City of Albuquerque Stormwater Construction Site Inspection Report

ESC File No.	E17E011B	Project Name:	XRAMM		
NPDES Id. No.	NMRT004FO	Location:	5800 Jefferson St NE		
6/13/2023	Owner	Contractor			
Operator	Jefferson 25 XRAMM QOZB, LLC	Enterprise Builders			
Contact name & title	Jeff Jesionowski	David Lundsten			
e-mail	jeff@amcdevelopment.com	dlundsten@ebnm.com			
Contact Phone #	259-0991	452-7639			
COA Inspector	Chancellor English	Start/End Time:	2pm		
Construction Phase:	infrastructure complete northern lot not stable				
Type of Inspection:	Regular	Storm Event	Post Storm Event >0.25"	311/Complaint	Follow Up
Weather at time of inspection?	Clear		Temperature: ~	80	
Estimated date of last storm 0.25" or greater	5/22/2023

EROSION AND SEDIMENT CONTROL PLAN

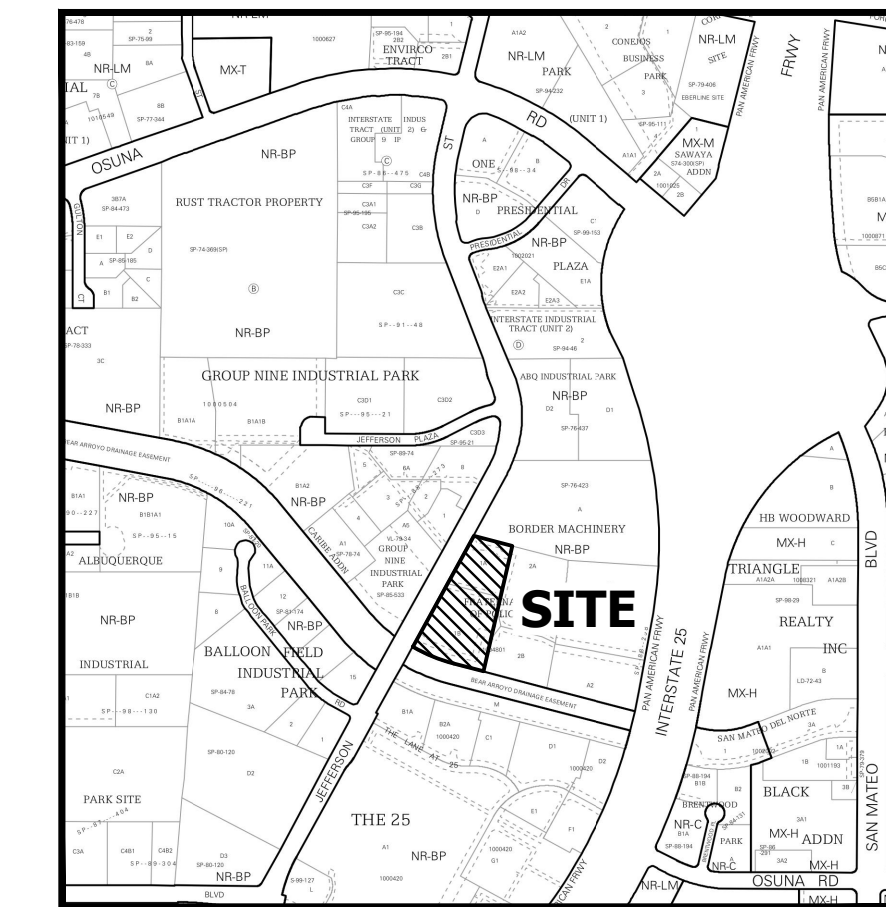
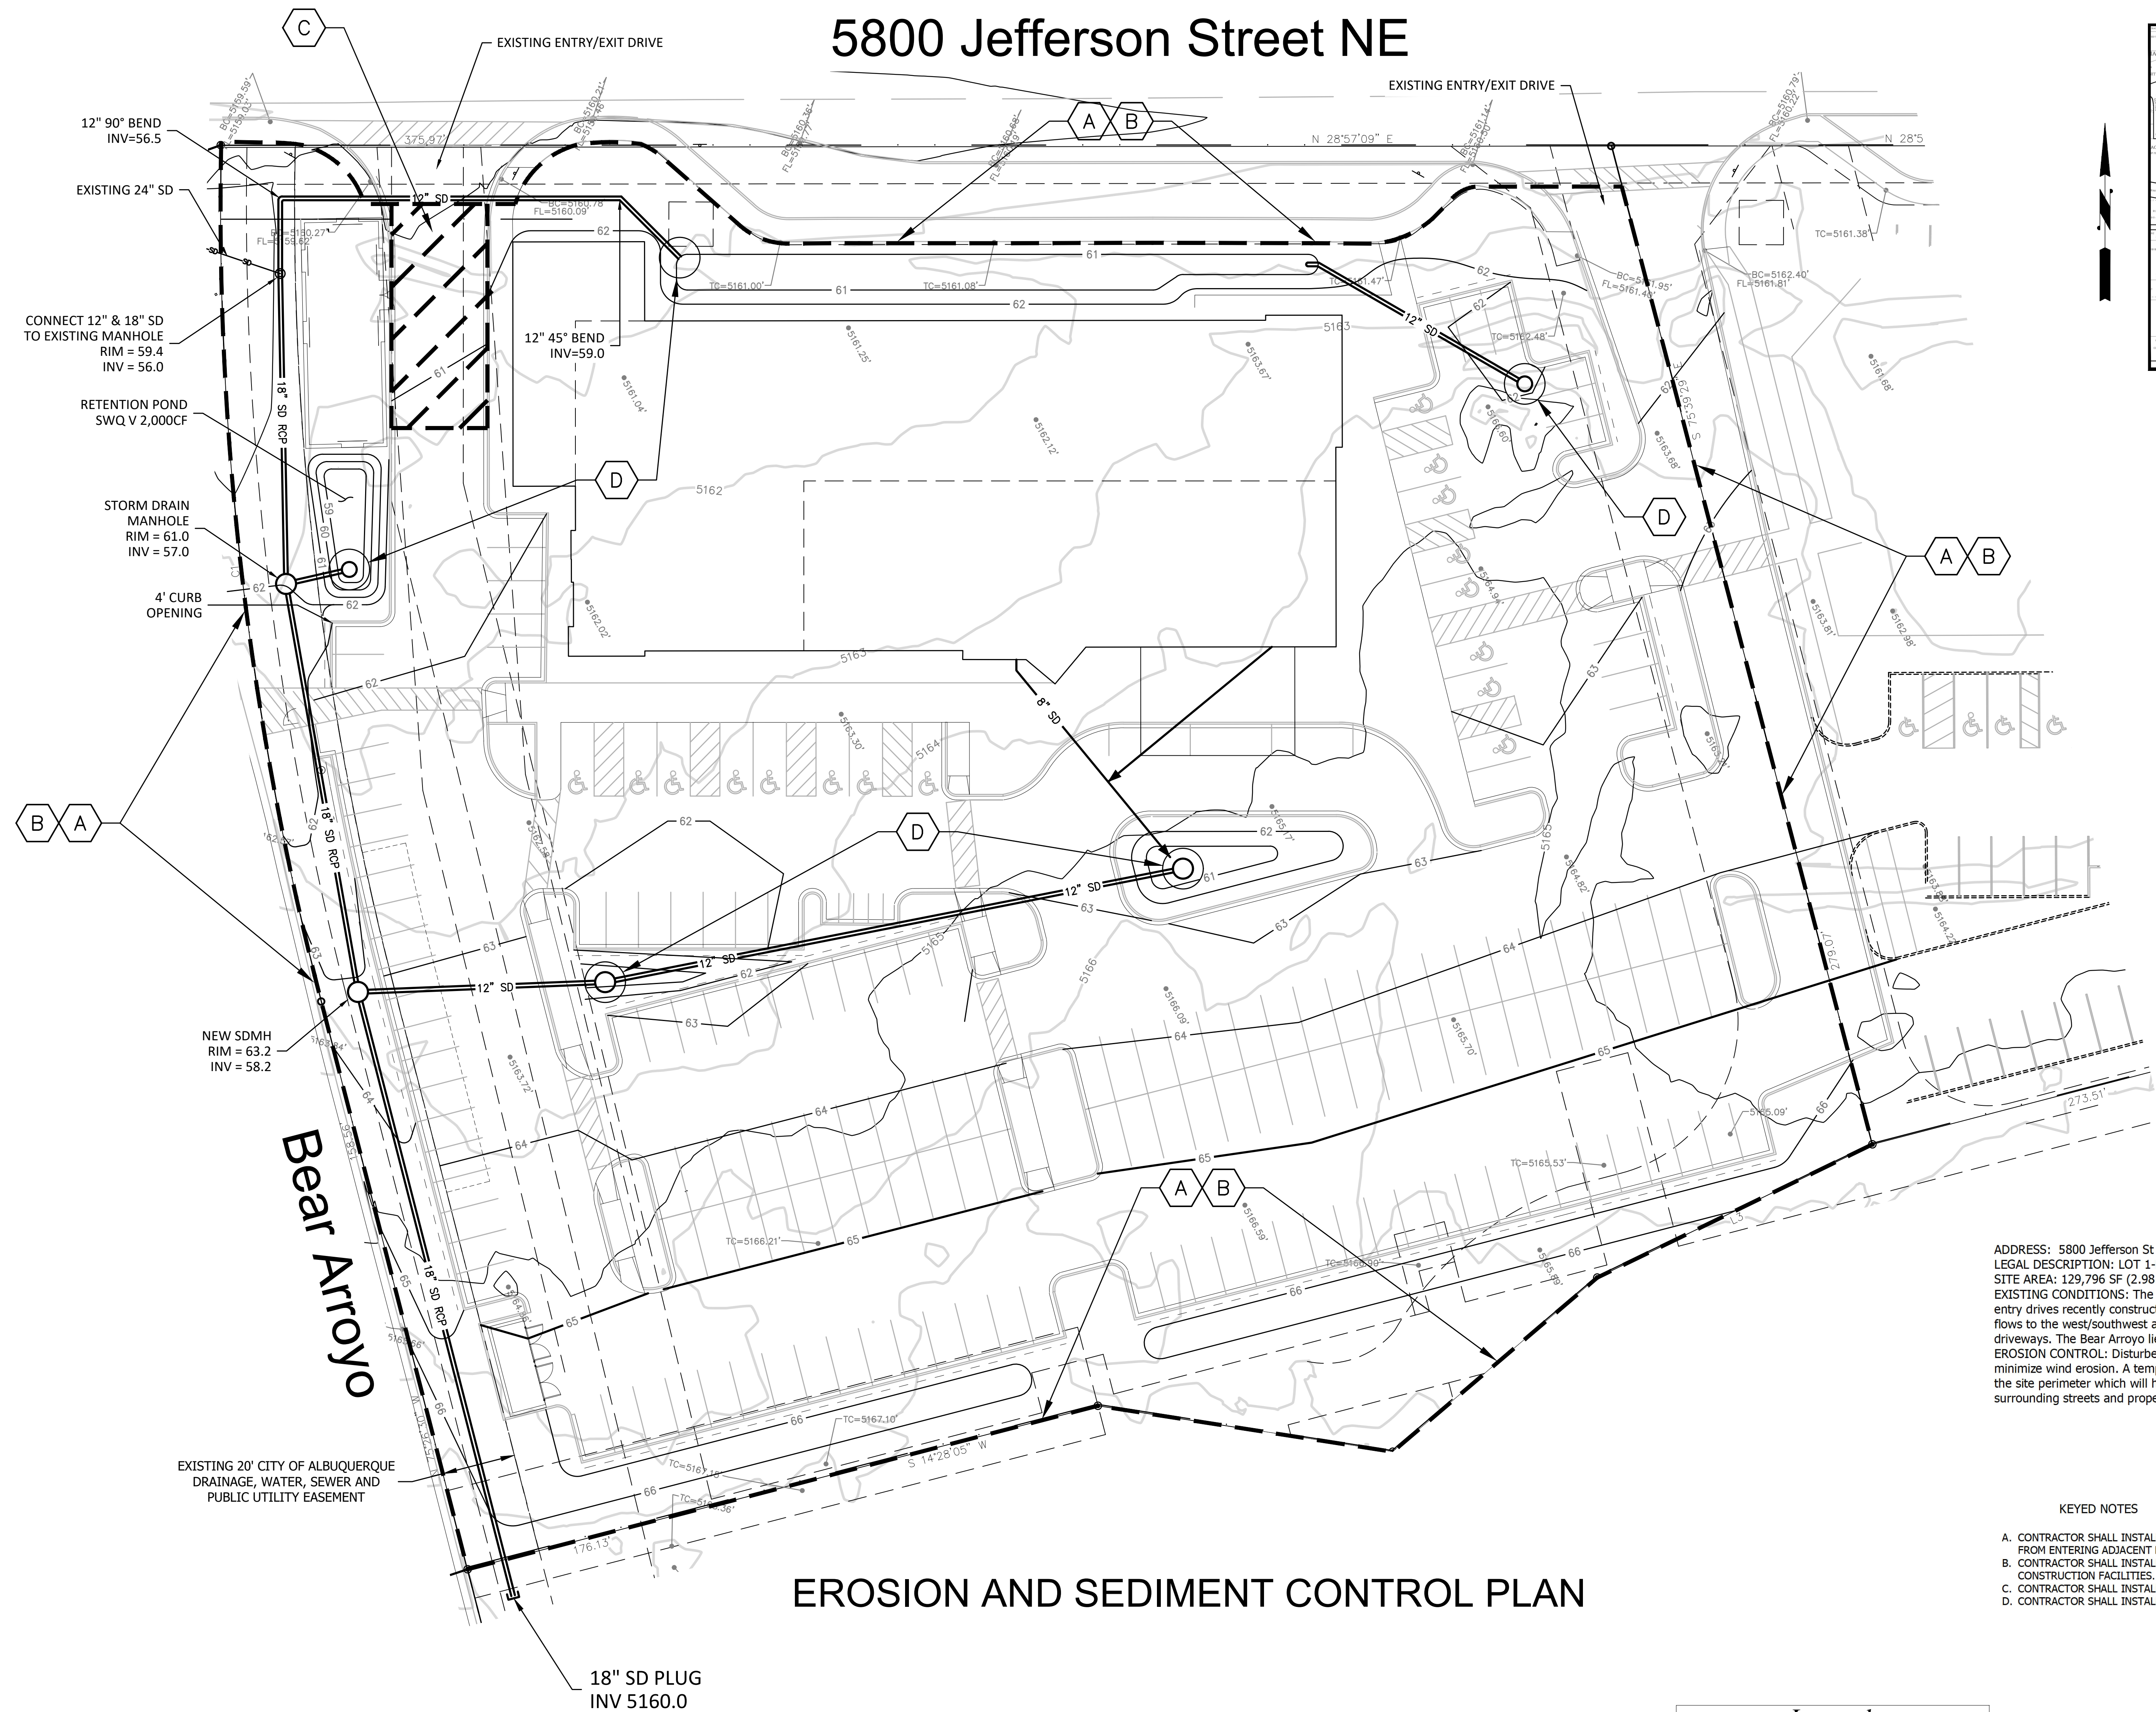
Item Number	Deficiency/ Corrective Action				
1	The lot north of the construction area is not stabilized. The City received an amended ESC plan to include this northern lot on the map which includes instructions to stabilize it using 2" of pit run gravel. Install and place gravel to have no bare soil spots to stabilize the northern lot or provide stabilization that satisfies one of Parts 8.2.1, 8.2.2, or 8.2.3 of the CGP.				
2	In accordance with City Ordinance § 14-5-2-11(C)(1), self-inspections must continue until the site is "determined as stabilized by the city." The property owner/operator is responsible for determining when the "Conditions for Terminating CGP Coverage" per CGP Part 8.2 are satisfied and then for filing their Notice of Termination (NOT) with the EPA. Each operator may terminate CGP coverage only if one or more of the conditions in Part 8.2.1, 8.2.2, or 8.2.3 has occurred. After filing the NOT with the EPA, the property owner is responsible for requesting a Determination of Stabilization from the City.

Notes:	
Previous violations are outdated SWPPP, Washout, and Waste disposal. Stabilization of the northern lot has been added to ESC Plan and an infromal violation issued for stabilization not being in place.
